Development Facilitation Team (DFT) – Review Comments

Project No: PR-2022-006627 Date: 06/11/2025 Agenda Item: #4 Zone Atlas Page: M-14

Application For: MAJOR_PLT-2025-00005 – PRELIMINARY PLAT

Project Name: 335 Woodward Rd SE

PLAT OF
LOTS 1 THRU 4
MARIOS CATERING

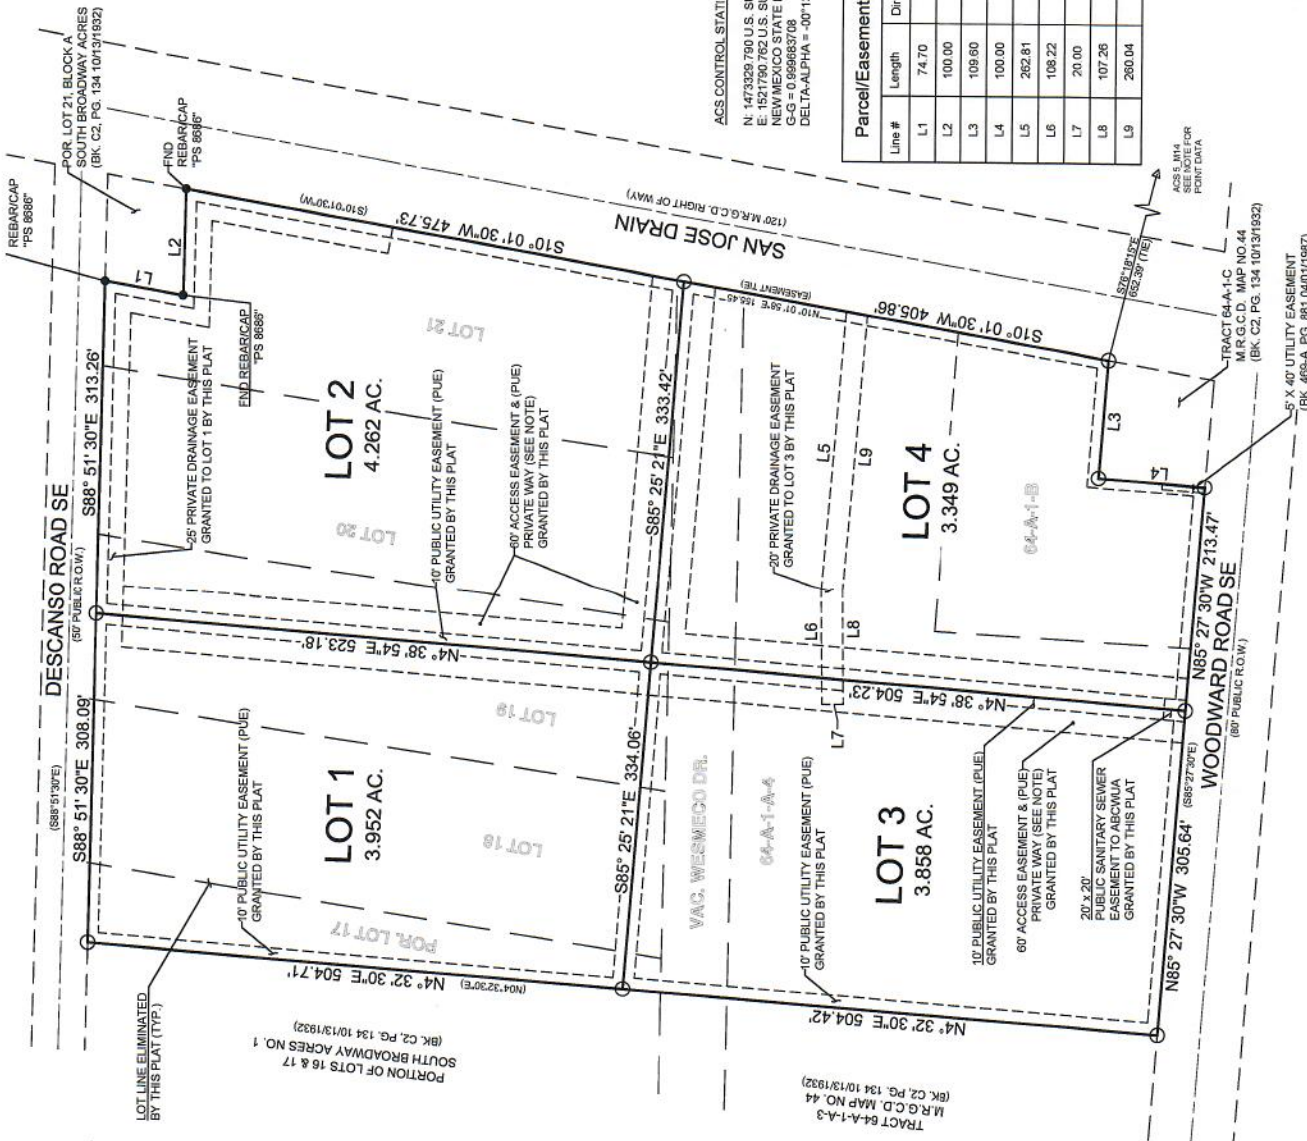
1. The proposed 20' easement cannot be bisected by the property line. Please move it or show two 10' easements on both lots.
2. Please add the following note to the plat

5. Please add the following note to the plat
 - a. "Existing public water and/or sanitary sewer infrastructure may not be constructed or sized to adequately serve potential future development. Improvement or upsizing of existing public infrastructure may be required as a condition of future development approval."

A1.1

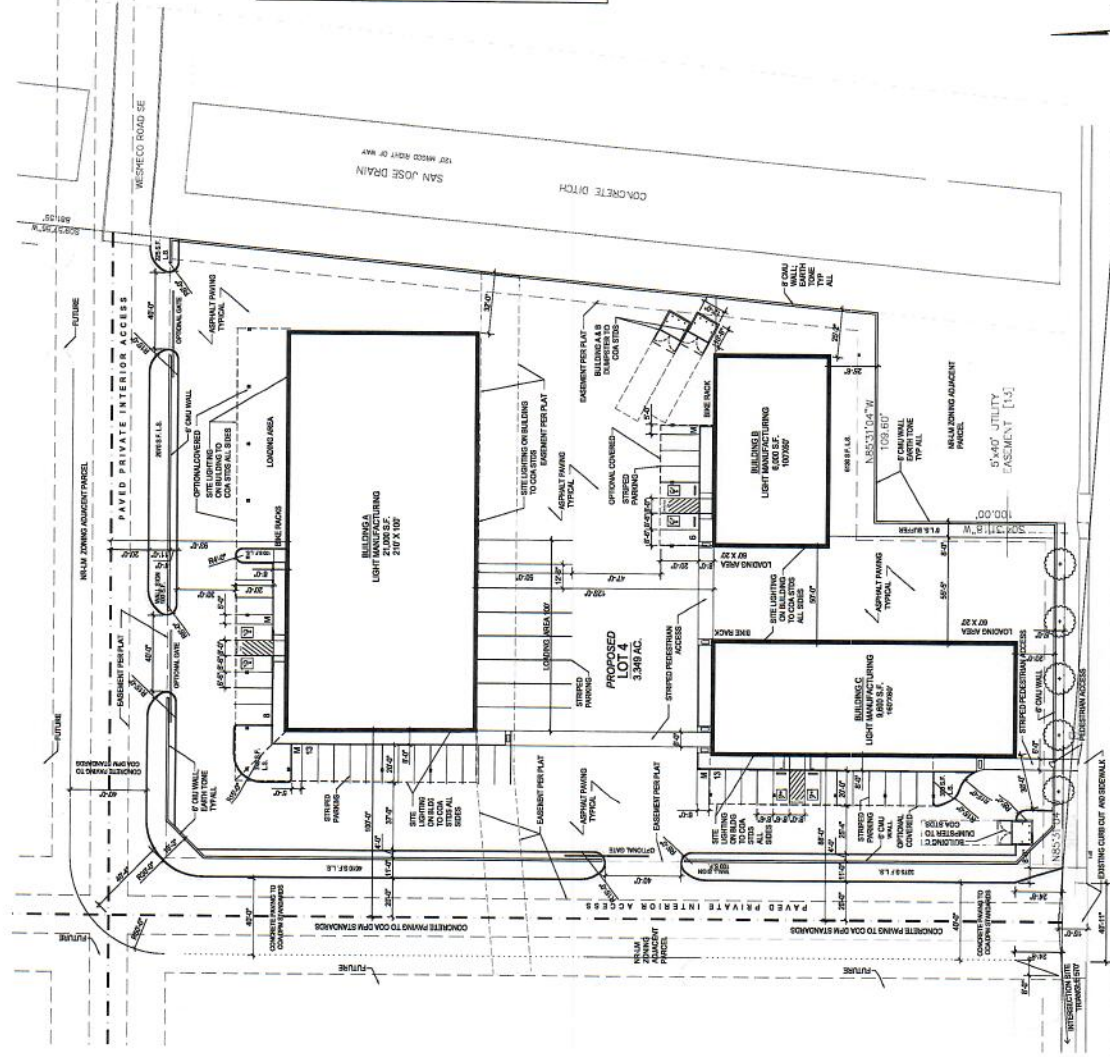
1. Woodward is a Major Collector and requires 6' sidewalk with 5' to 6' landscape buffer. Descanso is a local road and requires 5' sidewalk with a 4' to 6' landscape buffer. Proposed sidewalk on Descanso meets requirements. Existing sidewalk on Woodward is listed as 5' where 6' is required. Please provide for widening or you may request a determination with a justification letter.
